**From:** Martin Hill <Martin.Hill@arun.gov.uk>  
**Sent:** 06 July 2021 11:28  
**To:** Planning.Responses <Planning.Responses@arun.gov.uk>  
**Subject:** RE: Planning Consultation on: BR/134/21/PL

Comments from Private Sector Housing:

**Application No:** BR/134/21/PL

**Description of Works:** Sub-division of existing four-bedroom flat on first and second floors to create 2no. 1-bedroom flats, insertion of three dormer windows at second floor, insertion of rooflights to north and south elevations and removal of window to western elevation. This site is in CIL Zone 4 (Zero Rated) as flats.

Second Floor Plan
As Proposed
1:50

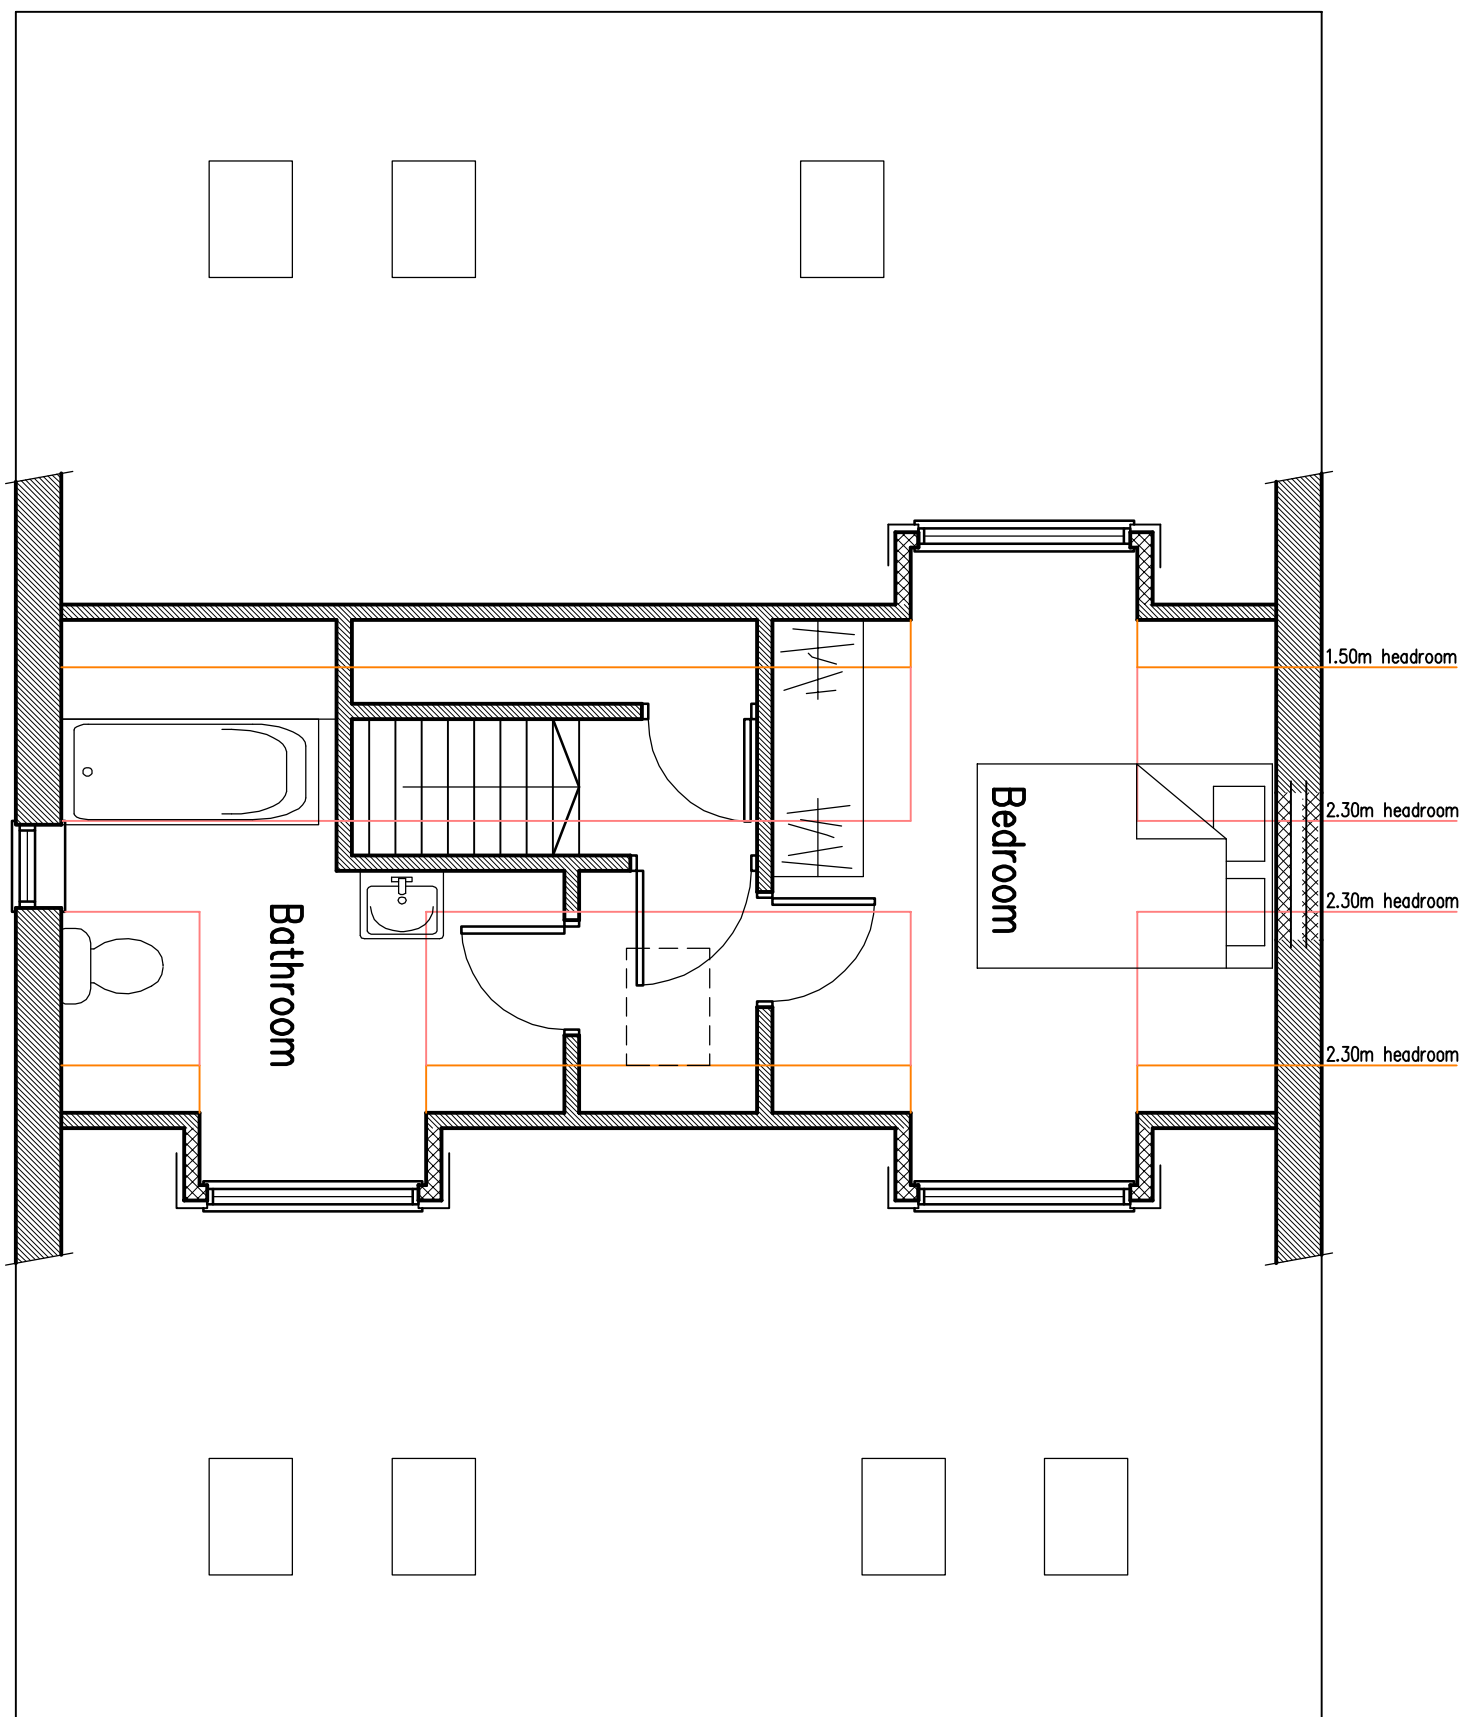
- A room where the only escape route is through another room is termed an “inner room” and poses a risk to its occupiers if a fire starts unnoticed in the outer room. The escape route from the bedroom in Flat 2a is via a lobby area. Private Sector Housing cannot determine the benefit of having this lobby on the second floor. Benefits of removing/not installing the access door on the second level overcomes an inner room situation, but also the natural light from the skylight would be beneficial in providing natural illumination to the staircase. If the access door on the second floor is to be installed, the applicant must be aware of the need for the domestic grade fire alarm and detection system to extend into the lobby on the second floor, in addition to the top of the staircase on the second floor. Please see fire alarm requirements below for further information, however consultation with a Fire Risk Assessor and WSFRS should be made to determine the most appropriate level of fire alarm and detection system for this property.

- 30min fire resisting escape route, which would include providing a 30 minute fire resisting and self-closing fire door to the entrances of flats 2 and 2a. The fire doors to these areas must include a thumb-turn device for emergency egress, 3 fire-rated steel hinges, intumescent strips and cold smoke seals and an overhead self-closing device of a minimum Power Size 3.

- Grade D, LD2 fire alarm and detection system –
  - Interlinked mains wired smoke alarms with integral battery back-up located in the entrance lobby of flat 2 and flat 2a, plus at the top of the stairs of flat 2a located on both sides of the lobby entrance door on the second floor. If the second floor lobby door is not to be installed, one interlinked smoke alarm with integral battery back-up should be installed at the top of the landing area.
  - It is recommended to install Interlinked heat alarms with integral battery back-up in each kitchen.
